Subject: FW: TSC Comments Kings Forest Project Application Mod 3 Service Station DA11/0565.04 (MP08/0194)

Subject: TSC Comments Kings Forest Project Application Mod 3 Service Station DA11/0565.04 (MP08/0194)

Within the limited time period provided, Council staff have reviewed the latest modification application, and the Department is requested to consider the following matters in the assessment of the application:

1 SITE PLAN
1:500

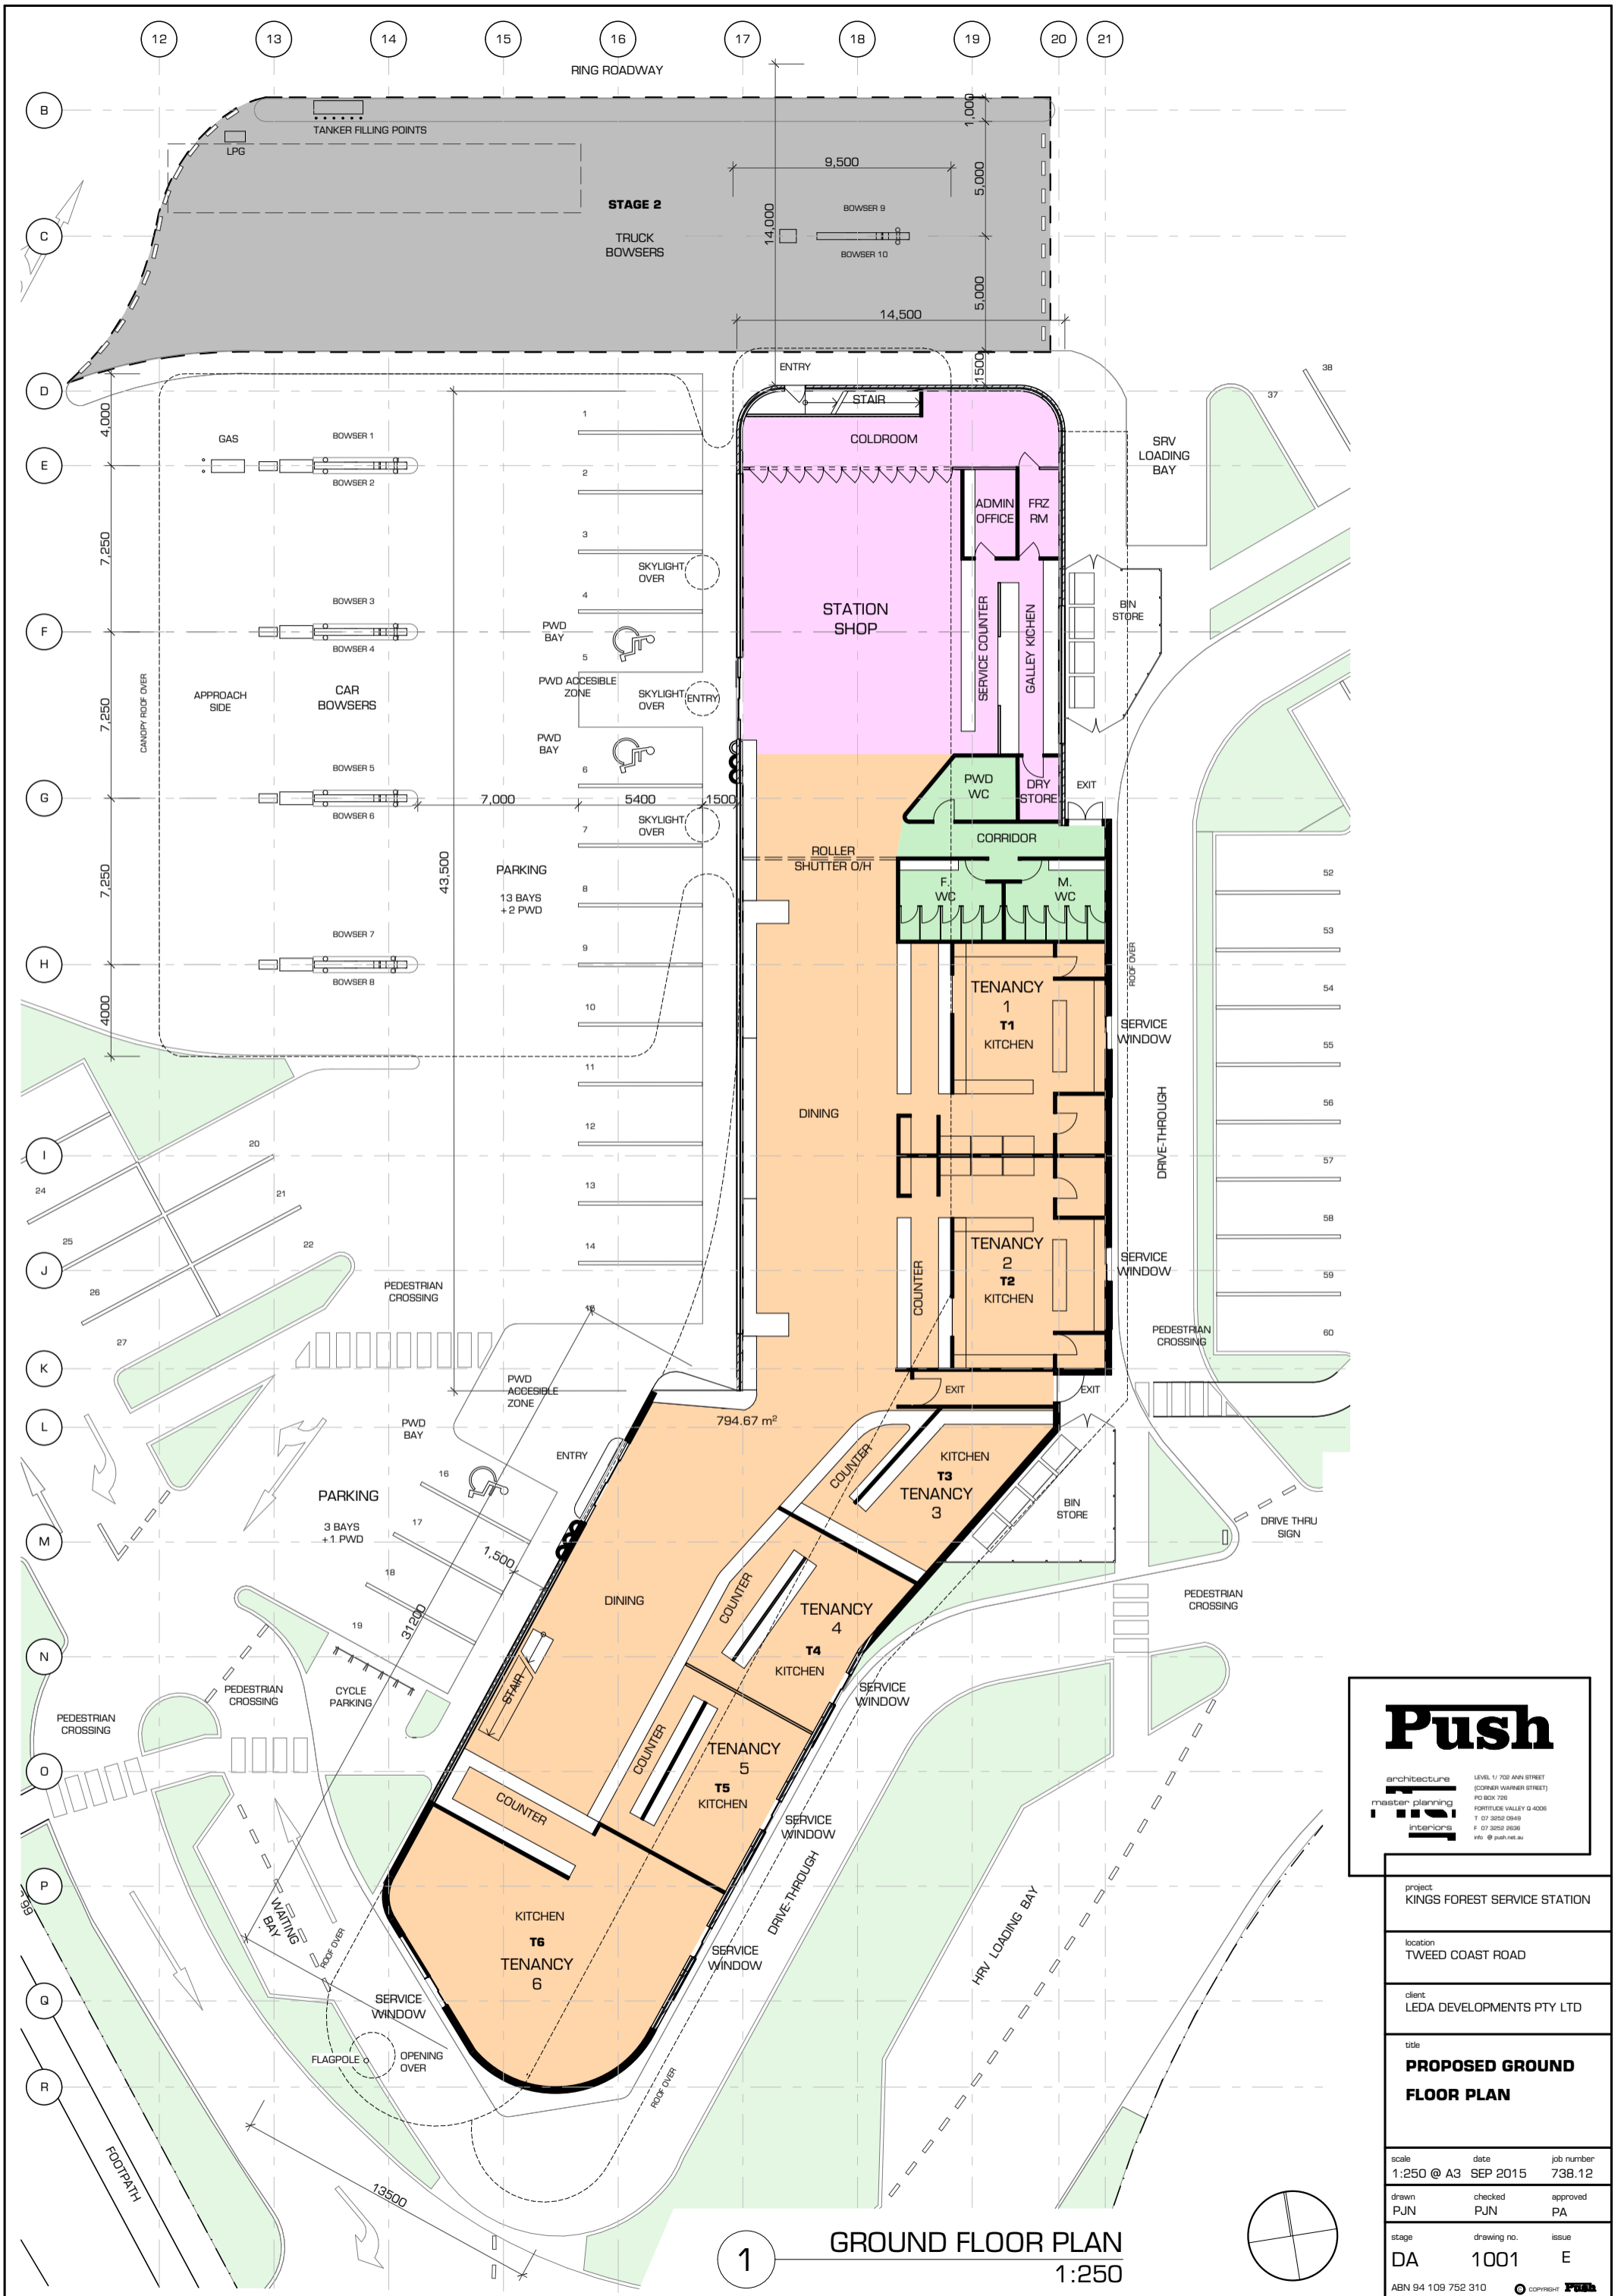
The outer 20m of the 50m ecological buffer appears to be nominated for car parking and bushfire asset protection which appears contrary to the approved Preferred Project Report which locates these uses outside of the ecological buffer. As a consequence of this the proposed koala exclusion fencing is now located 20m inside the ecological buffer contrary to PAC condition 46 which specifically requires such fencing to be located on the outer edge of the 50m buffer. The application provides no justification for this, incorrectly stating that: *This proposed modification maintains the approved strategies of the Koala Plan of Management for Kings Forest excluding Koalas from the development footprint area and positions boundary fencing in the previously approved locations.* (See p 15 of Modification Report).

1 ROOF PLAN
1:250

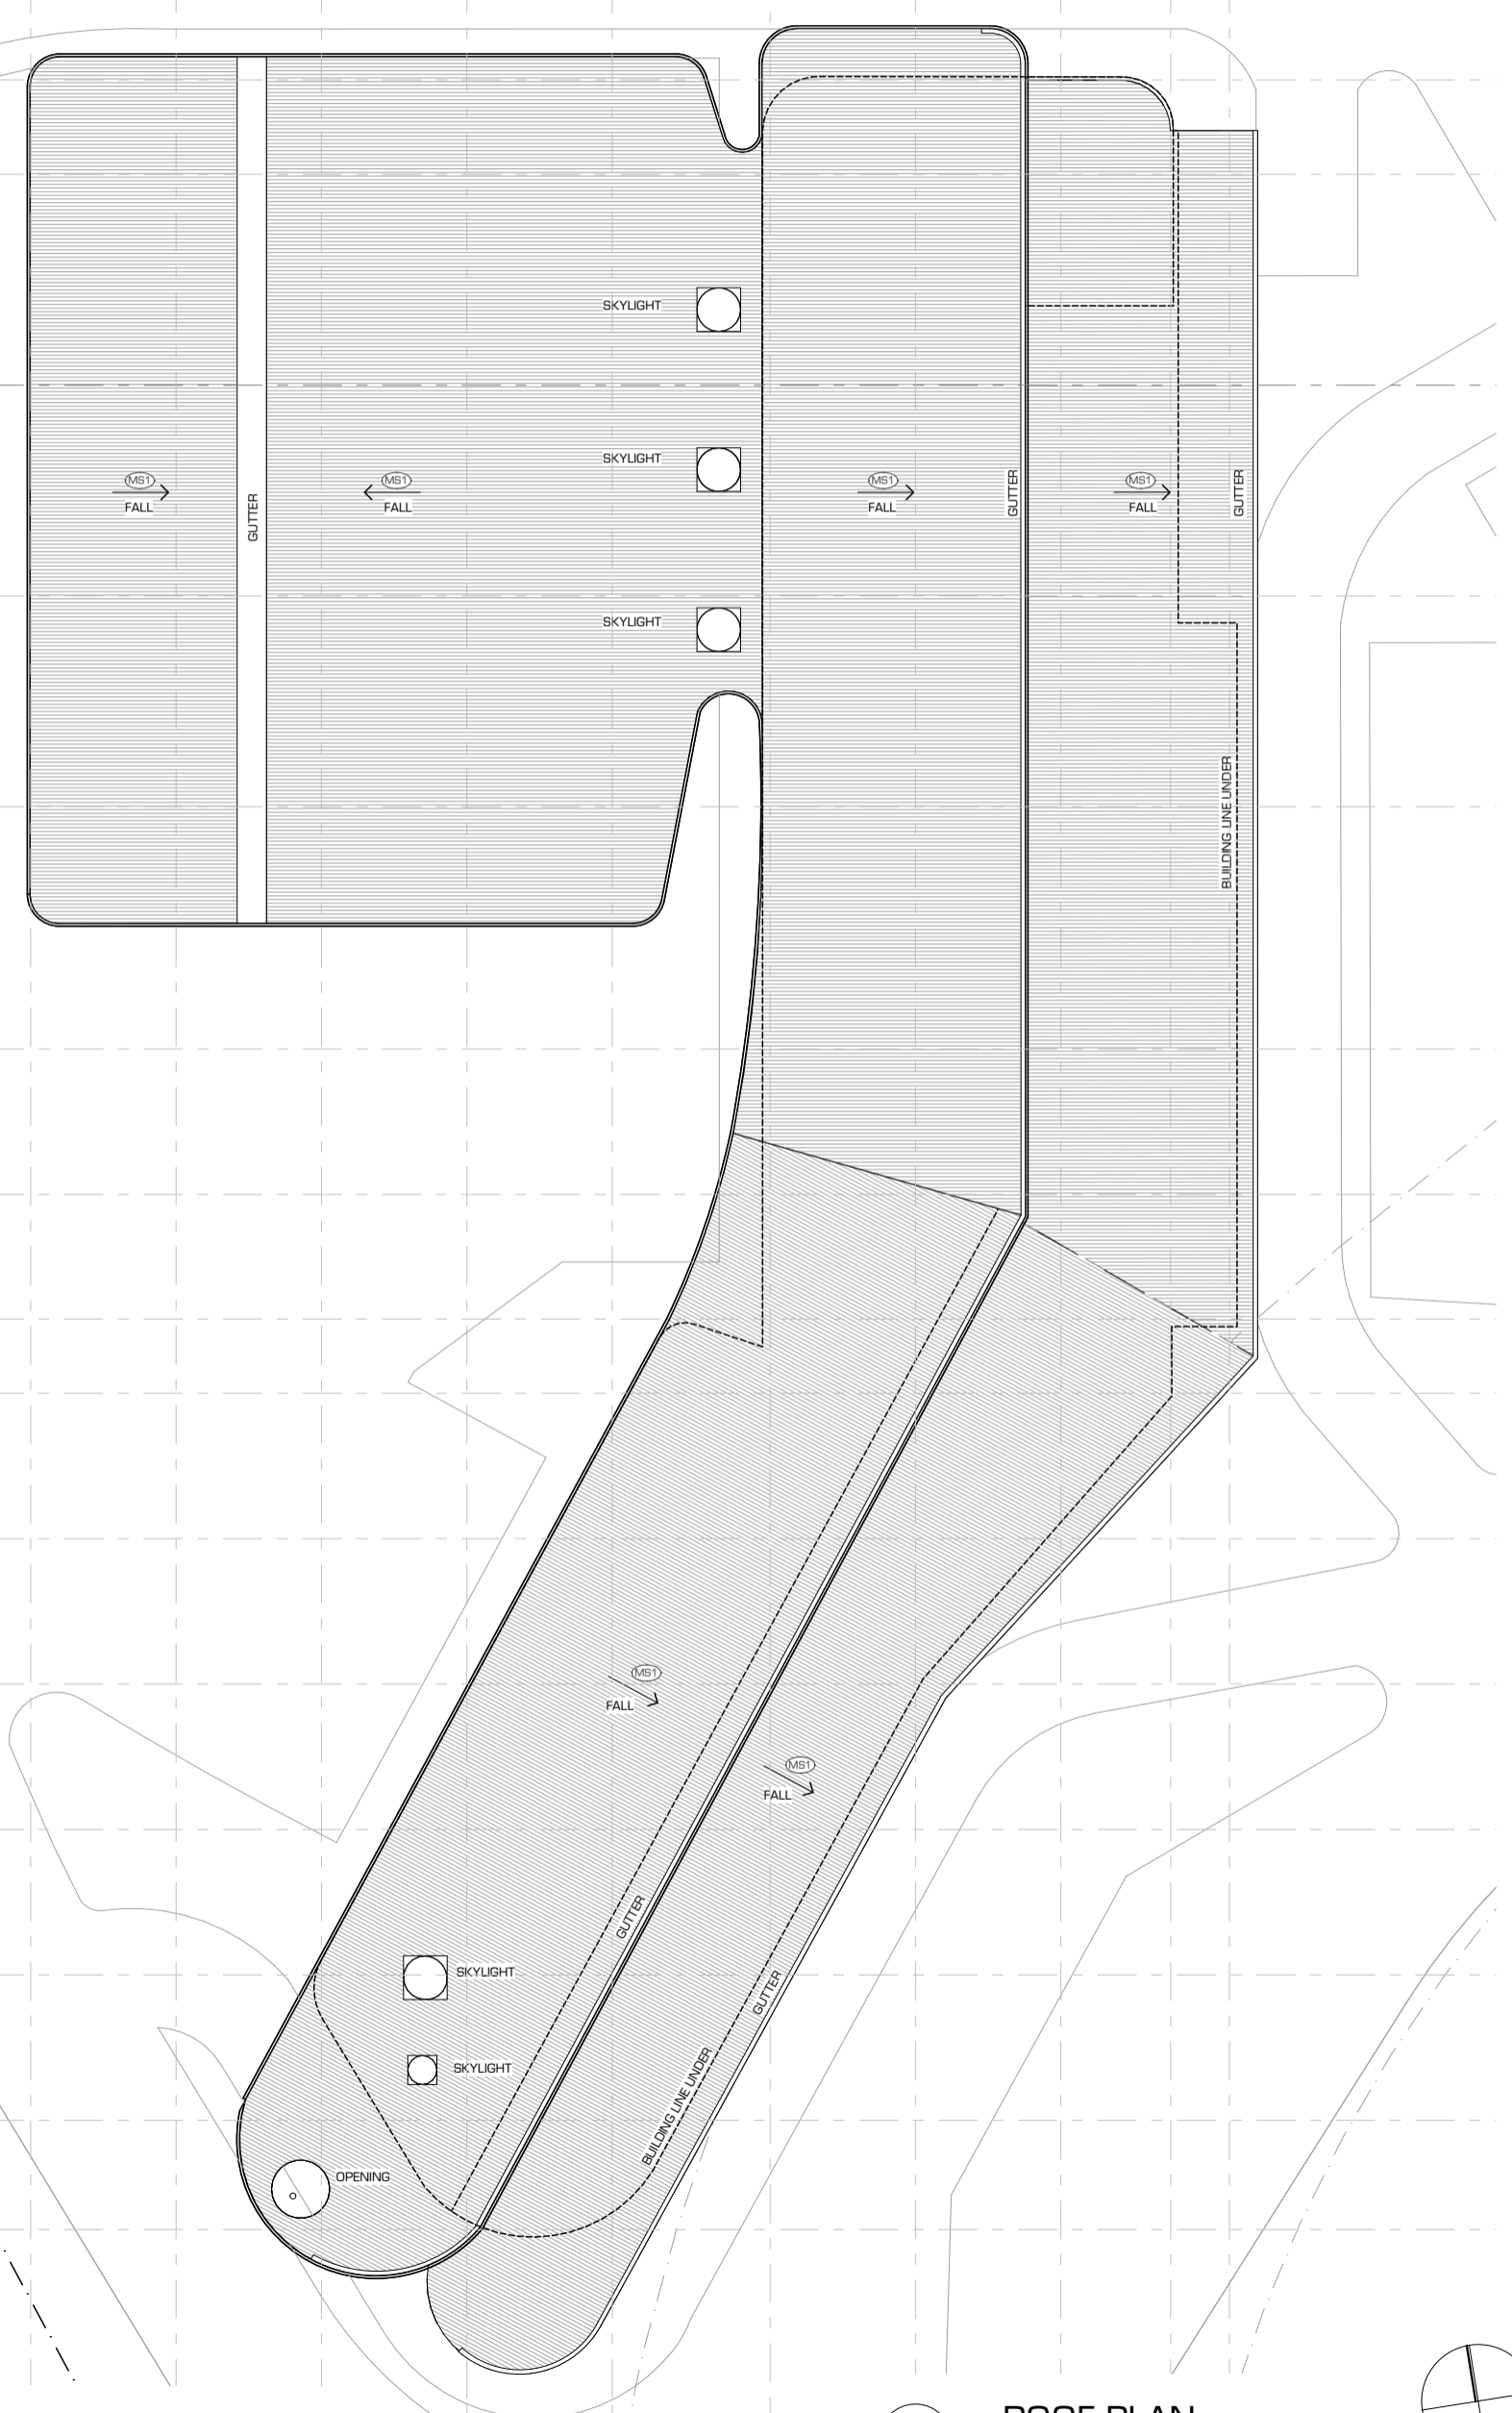
- Drainage grates over trafficable areas be well fixed to avoid rattling when a vehicle passes over the grate.
- Mechanical plant be designed and installed to comply with the noise criterion presented in Section 4. As final plant requirements are not known at this stage, additional acoustic assessment/s should be undertaken prior to Commencement of Use to confirm acceptable noise levels have been achieved; and be conditioned within the Development Approval. Based upon the assumed plant noise source levels, acoustic screening to the western dwellings is likely to be required such as locating plant on the eastern side of the service station building envelope; or incorporating acoustic barriers / enclosures at roof-top plant.
